Application no: H09-0732-11

Description: Details of vehicular access (Condition 4 of H09-0597-11)

Location: Plot 3 off Roman Bank
Holbeach Bank
Spalding
Lincs
PE12 8BX
PE12 8BX

Amendment: Amended plan showing first 8 metres of new drive to be
to LCC requirements and specification

LOCATION & SITE LAYOUT PLANS.

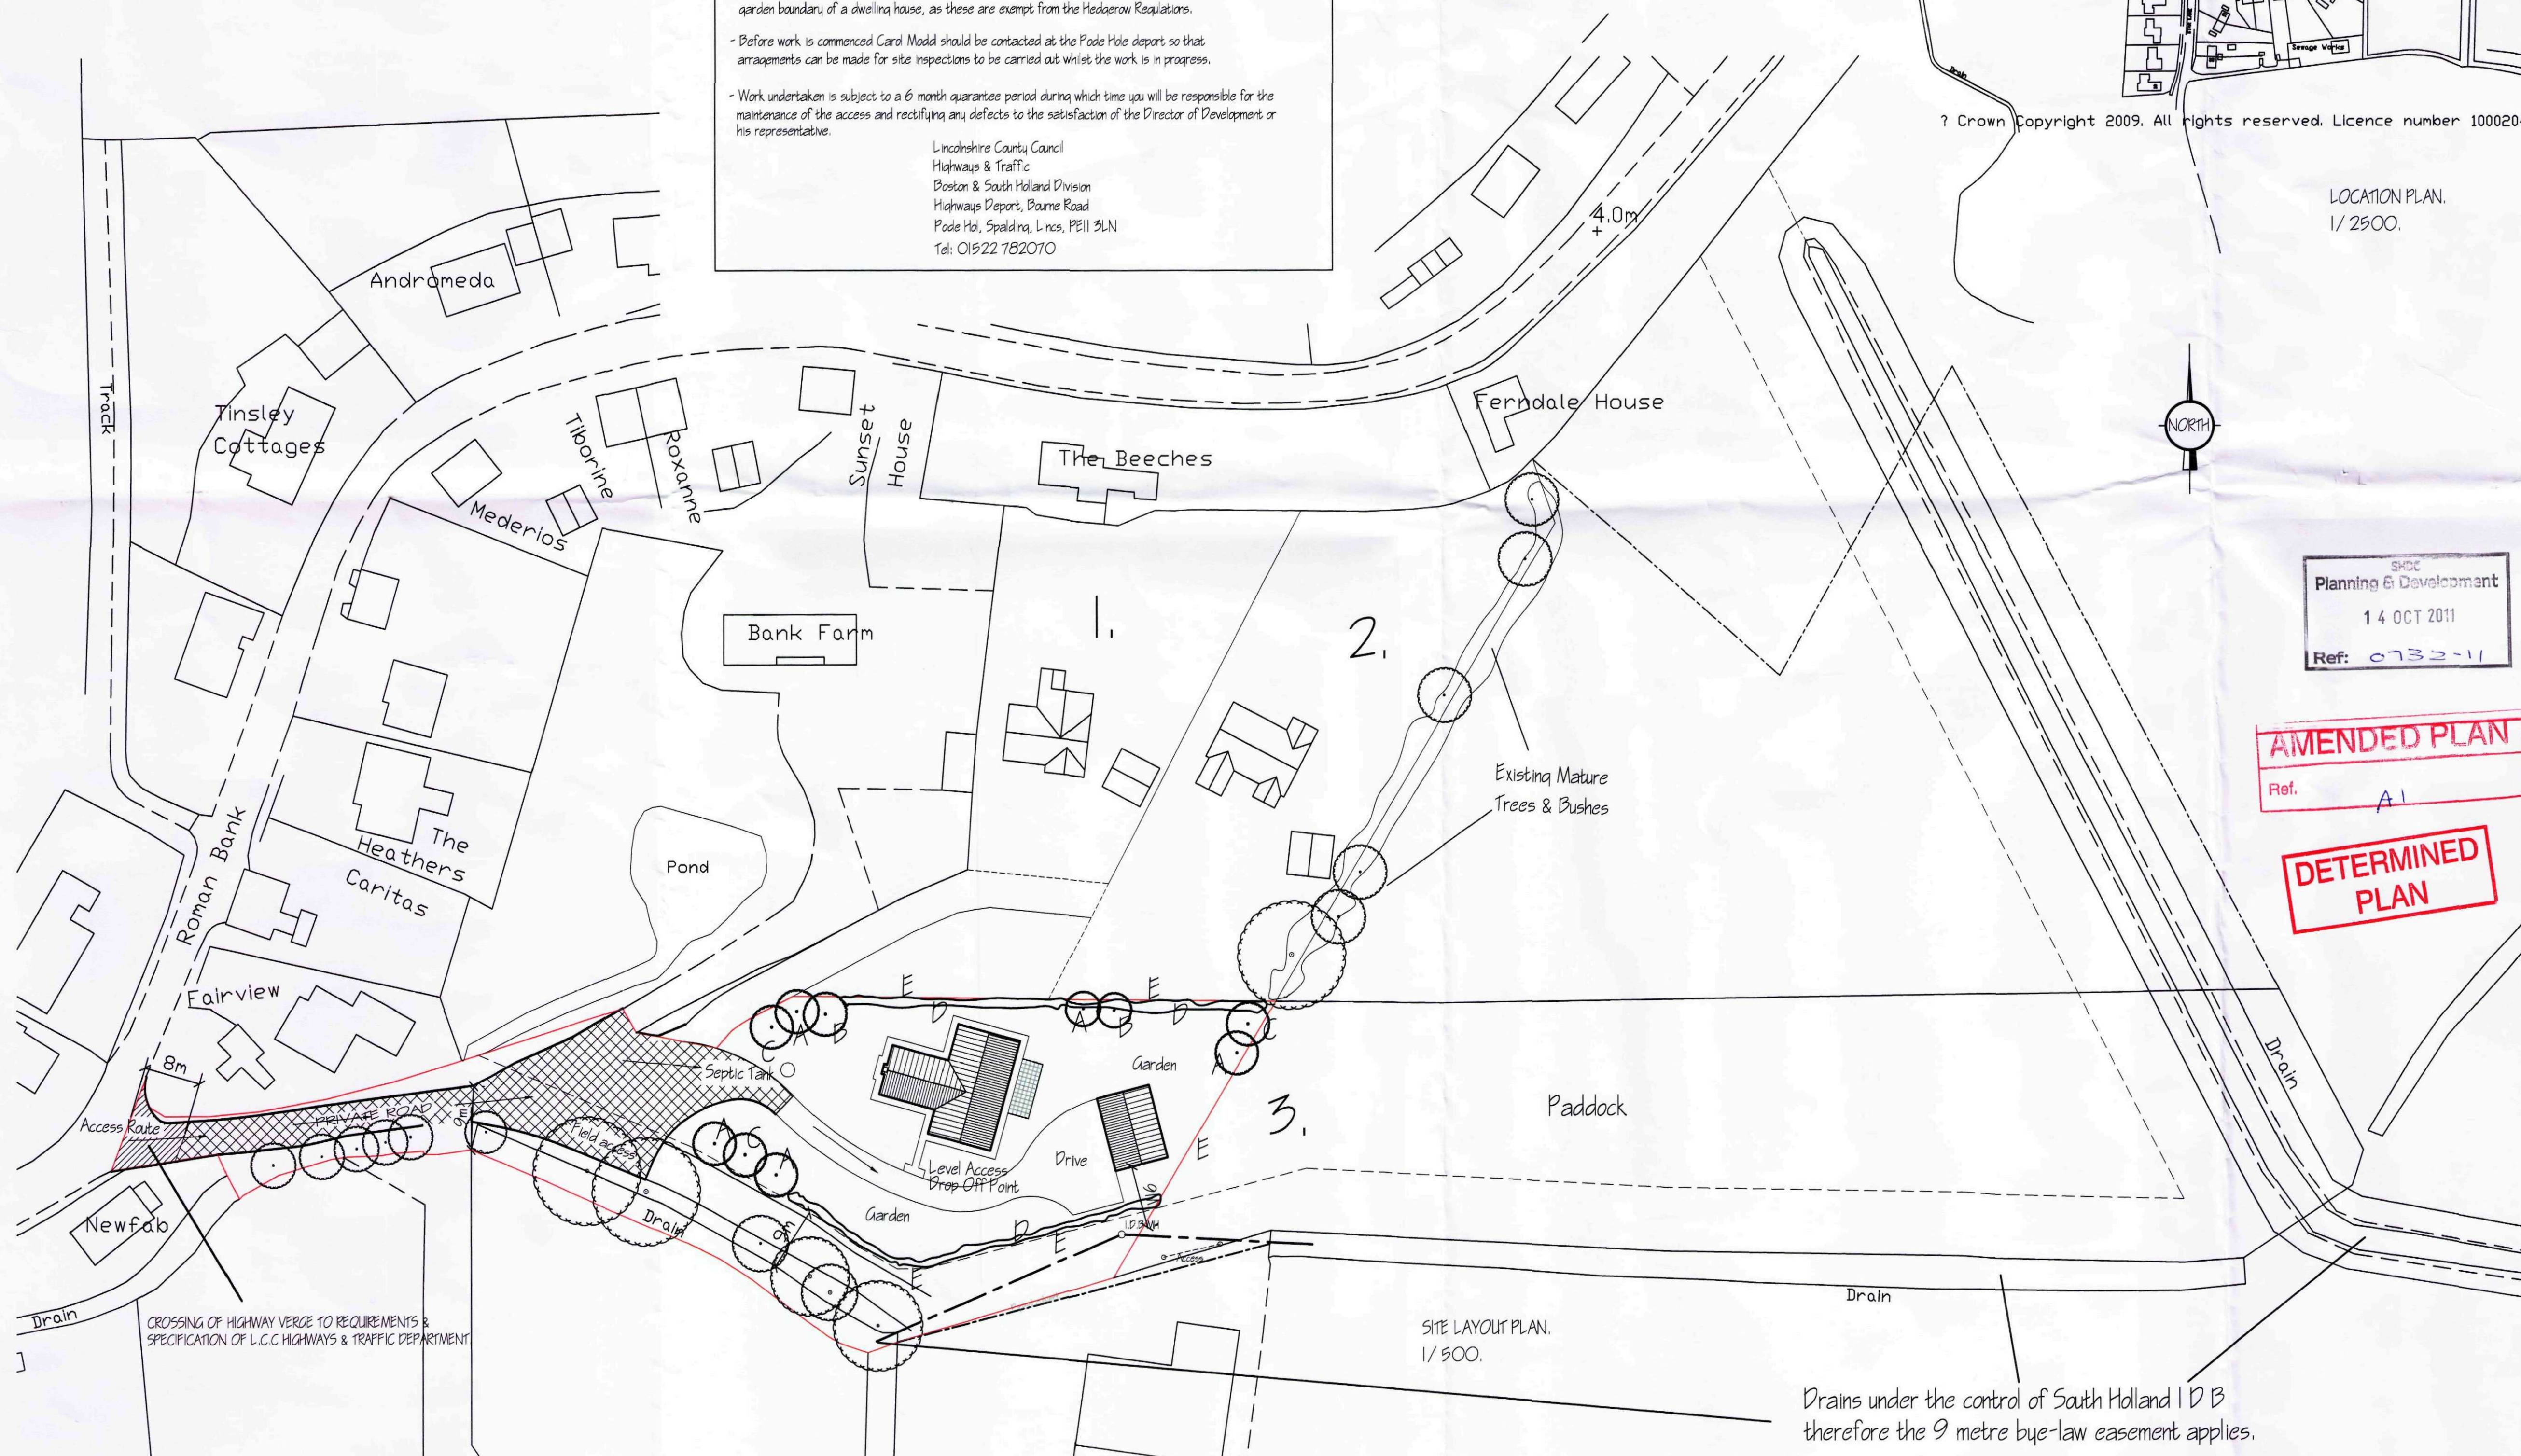
Highways have commented on the details submitted in the above application. There are 'no highways objection to the proposals for the private driveway, but the part of the access that falls within the existing highway limits must be constructed to the LCC Highways specification'.

The driveway is proposed to be constructed of an unbound material. The strip that crosses what is the highway verge needs to be of bituminous construction. Would you therefore amend the details submitted to take into account Highways specifications?

Attached is the amended plan showing the first 8 metres of the new drive to be to LCC Highways requirements and specification following email advise from Jon Sharpe this morning.
